Proposal: Application for approval of details reserved by condition imposed under BR/54/16/PL relating to condition No. 7 (Construction management plan), 10 (Surface water drainage), 12 (Watercourse), 14 (External lighting scheme), 15 (Noise), 16 (Public sewers), 17 (Foul & surface water sewerage disposal), 18 (Cars), 19 (Roof plant), 23 (Landscaping scheme), 24 (Tree retention & protection plan), 25 (Programme of archaeological work & scheme of investigation), 26 (schedule of materials) & 34 (Programme of ecological work)

Site: University of Chichester, Upper Bognor Road, Bognor Regis, PO21 1HR.
BR/214/16/DOC

Southern Water cannot recommend discharge of condition 10, 16 and 17 relating to foul and surface water drainage.

S185 DEVELOPER DIVERSION PROPOSALS

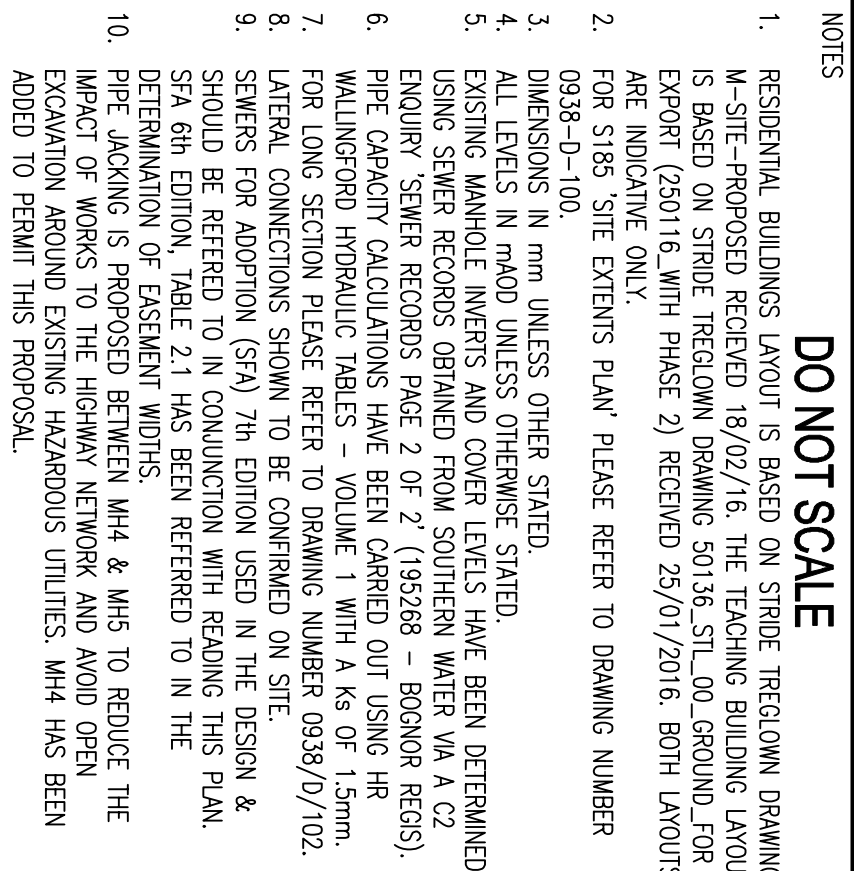
The public sewer diversion proposals should be agreed and approved by Southern Water under Section 185 of the Water Industry Act before the condition relating to protection/ diversion of public sewers can be discharged.

As indicated in our previous correspondence there is insufficient capacity within the existing foul sewerage system to accommodate the proposed development flows. Relevant infrastructure is to be provided to service the development. Further to provision of indicative scope of improvements required, an applicant is required to obtain Southern Water's approval for these works (combined with public foul sewer diversion – see paragraph 2).

TITLE: PRELIMINARY STORMWATER DRAINAGE FOR COORDINATION

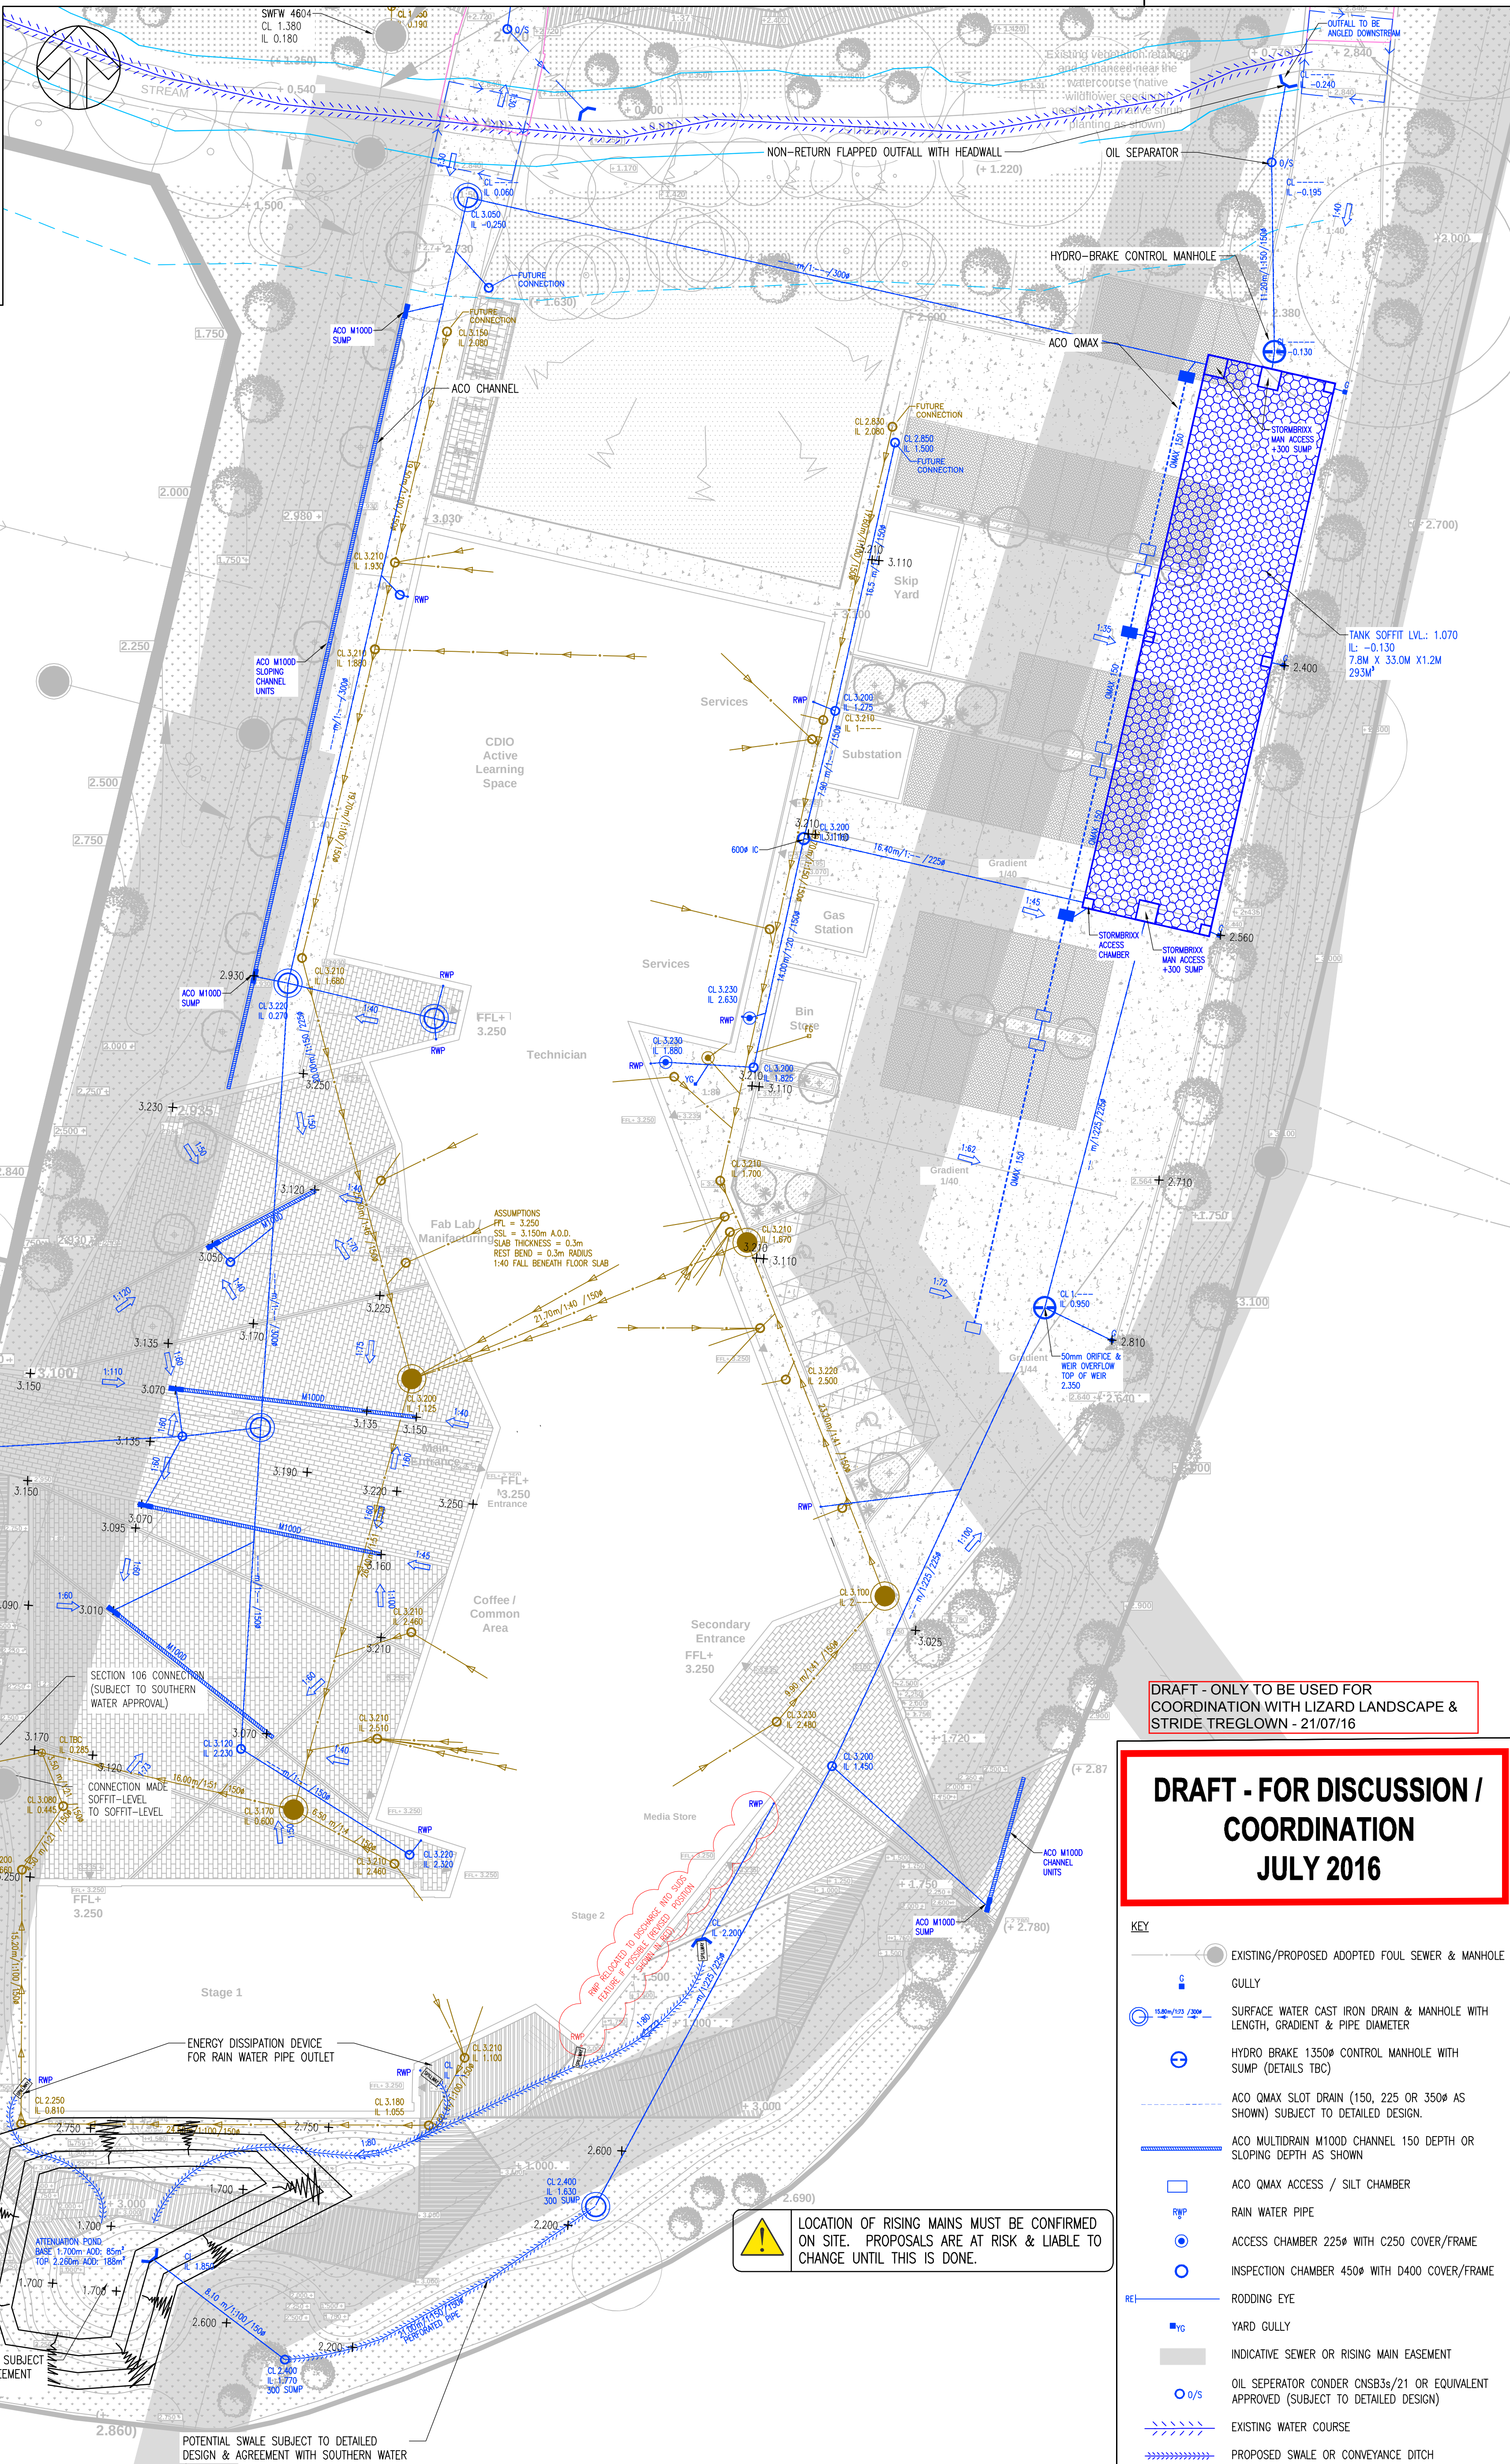
Construction of permeable paving over or within clearance distance of public or adoptable sewers will not be acceptable.

No new ponds, swales or other water conveying or retaining features should be located within 5 metres of the public or adoptable sewers.

The proposed on site foul and surface water drainage is not adoptable by Southern Water.
